From: Hill, Grace <Grace.Hill@e-lindsey.gov.uk>
Sent: 15 September 2025 15:35
To: Hill, Jess <Jess.Hill@sholland.gov.uk>
Cc: De-Ruyck, Chris (ELDC) <Chris.De-Ruyck@e-lindsey.gov.uk>
Subject: H09-0796-25 ecology comments

H09-0796-25 - Land East of Forest Way Holbeach Spalding Lincolnshire
Proposed Erection of 2 Bungalows

Documents reviewed:

PROJECT | Wignals Wood,
Wignals Gate,
Holbeach,
Spalding, Lincs
DATE | July 2025
TITLE | Biodiversity Net Gain Plans
SCALE | As Shown
ORIGINAL SIZE | A1
DRG STATUS | PLANNING
DRAWING NUMBER | LDC4657 - 05

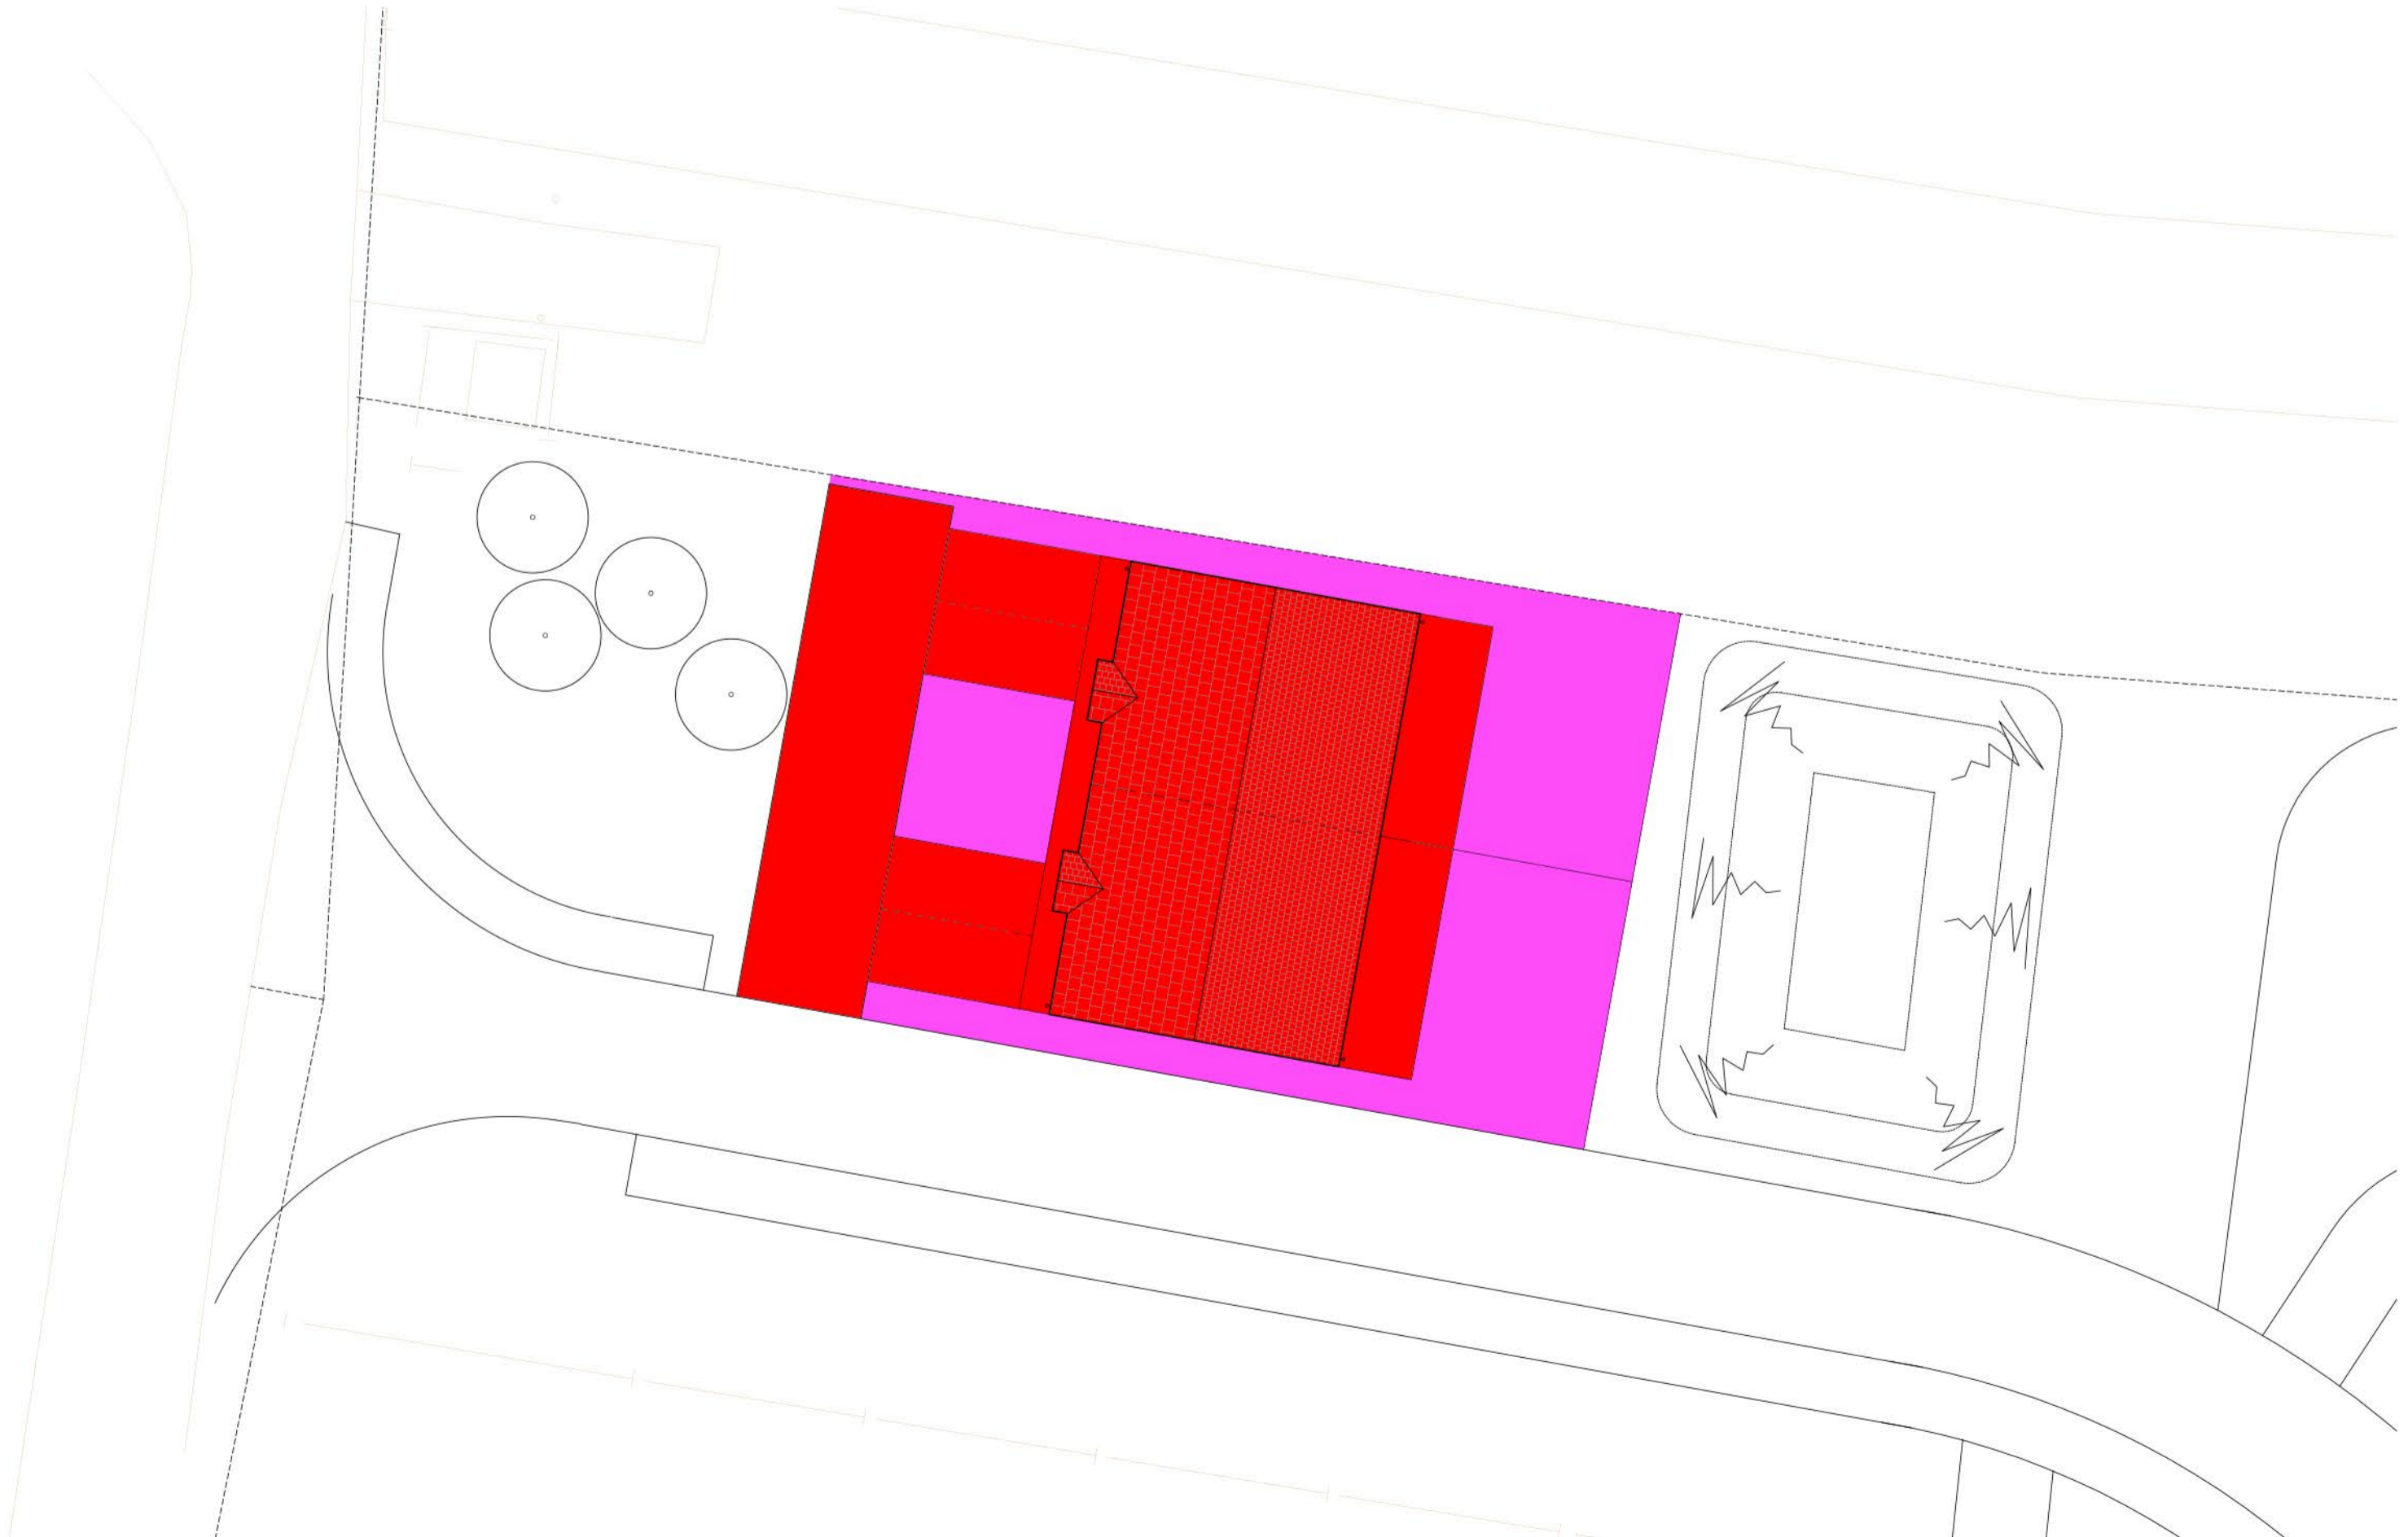
- BNG small site Metric
- BNG Plans
- Small sites BNG statement

- Overall, the biodiversity assessment and metric calculations appear rigorous, and we can have confidence in their conclusions. In this case the metric indicates that 10% mandatory net gain cannot be achieved on-site, and therefore the proposals require 0.1749 area-habitat units off-site. These will need to be secured pre-commencement and can be achieved via 2 routes:

1. Bespoke habitat creation/enhancement could be undertaken by the applicants on land they own elsewhere or in agreement with another landowner. To discharge the biodiversity gain condition the applicants would have to secure the appropriate habitat creation/enhancement by either entering a section 106 agreement with the local authority or through undertaking a conservation covenant with a responsible body pre-commencement.

2. The applicants could purchase the appropriate number of units from an off-site habitat bank and evidence this to the authority pre-commencement. This can be achieved through the applicants contacting an off-site unit provider, aka a habitat bank, (which has biodiversity units registered on the national gain-site registry) to arrange a contract for the applicant to purchase the necessary units from the habitat bank. The habitat bank then notifies the national gain-site register to allocate the specifically referenced units to the applicant. To discharge the general biodiversity gain condition, the applicant provides us with this reference information and evidence of the purchase (e.g. a receipt or copy of the contract with the habitat bank) along with the biodiversity gain plan that they must submit to us pre-commencement. These details are also recorded within a finalized version of the metric submitted with the gain plan. The authority can then independently confirm the unit transfer by checking the unit references against the national gain-site register and then approve the gain plan to discharge the Biodiversity Gain condition.

Conclusion: There has been sufficient evidence provided to determine this application, as long as the mandatory 10% net gain is achieved through securing offsite units pre-commencement.
